CITY OF ALBUQUERQUE

July 20, 2017

**RE: McMahon Market Place
Amended Drainage Management Plan
Stamp Date: 7/13/17
Hydrology File: A11D011G**

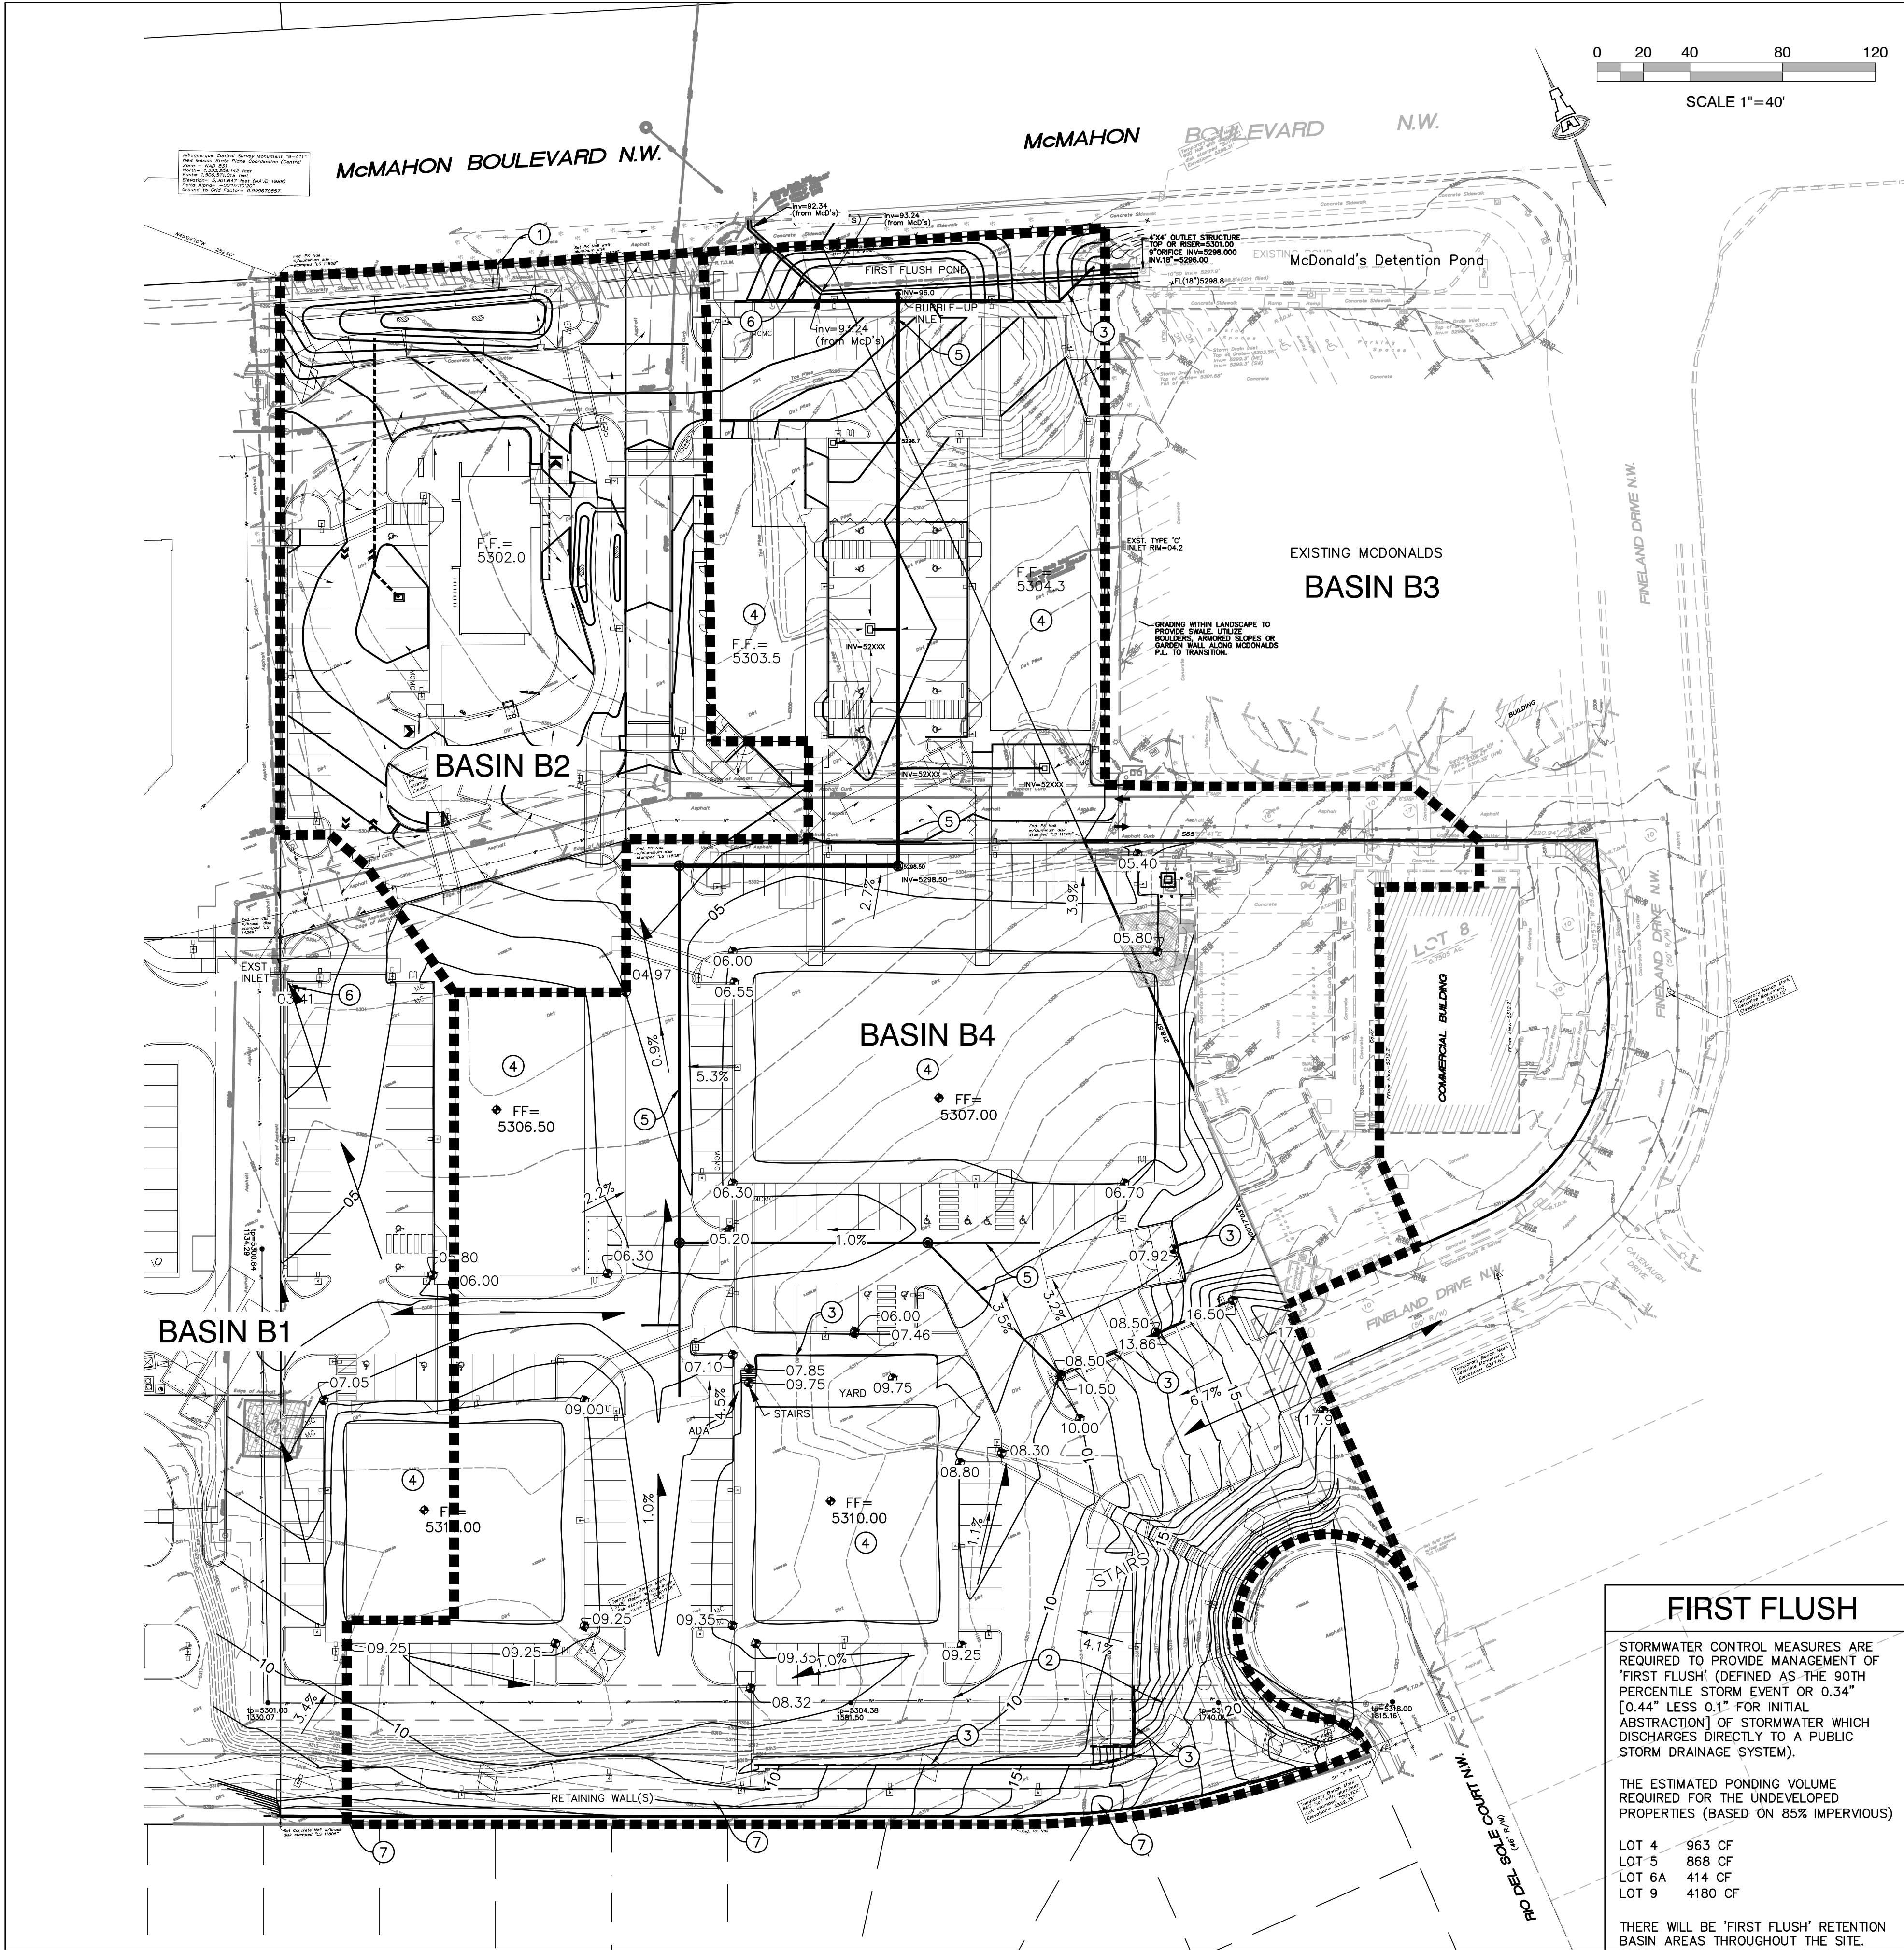
1. Under Project Information, the benchmark information and the flood hazard information are duplicates. These notes are under the Project Data. These can be removed.
2. Under Project Data, the second flood hazard information is a duplicate. This can be removed.
3. Under Project Information, the off-site information can be placed under the Project Data.
4. Under Project Data in the First Flush Retention note, The last sentence should read; "Storm water will then either free discharge (85% land treatment 'D') to McMahon Blvd pubic storm sewer or flow into a detention facility which will then regulate the discharge to McMahon Blvd pubic storm sewer."
5. Under Drainage Concept, Please correct required detention equation to read $19.8 - 13.55 = 6.25$ cfs.

6. Under Drainage Concept, for the detention required, please show the detention amount of what is proposed in the Lot 5 & 6A development and what is proposed in Lot 9. I know that the Lot 9 will be further phased.
7. Please provide in your supplemental information letter, an exhibit showing the conceptual detention pond for the Lot 5 & 6A development.
8. Please provide in your supplemental information letter, please provide calculations for the conceptual detention pond for the Lot 5 & 6A development.
9. Please provide in your supplemental information letter, an exhibit showing the conceptual control which will limit the discharge into the McMahon Blvd public storm sewer.
